From:Mike Brabbs
Sent:Mon, 15 Feb 2021 15:48:27 +0000
To:David Kelly
Subject:RE: 20/01596/OUT 1344 Evesham Road, Astwood Bank
Attachments:Form inc access.pdf

From: David Kelly <david.kelly@bromsgroveandredditch.gov.uk>
Sent: 23 December 2020 15:04
To: Mike Brabbs <mikebrabbs@masefields.co.uk>
Subject: 20/01596/OUT 1344 Evesham Road, Astwood Bank

Nos 1344 Evesham Rd

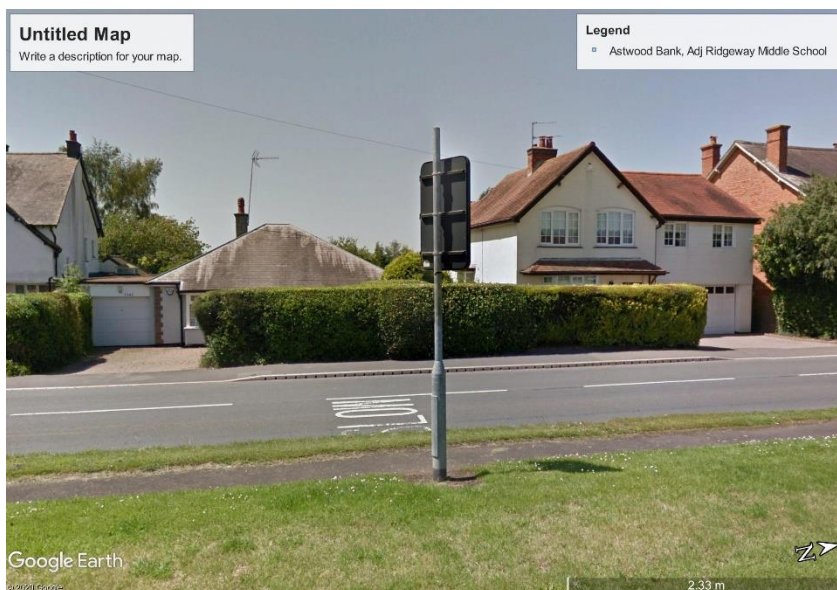
4. It appears from the photograph provided of the existing dwelling that the garage to the side would be removed to facilitate the proposal. Please confirm that this is the case and if so please submit a survey or evidence to demonstrate that there would be no harm arising to any protected species under the provisions of the Wildlife and Countryside Act 1981 and the Natural Environment and Rural Communities Act 2006.

5. The building south of No 1344 is a former office that is unused. This is to be removed. It does not communicate internally with No 1344.

This building has no roof void and is of modern construction. It offers no opportunity for colonisation by Bats or other protected species.
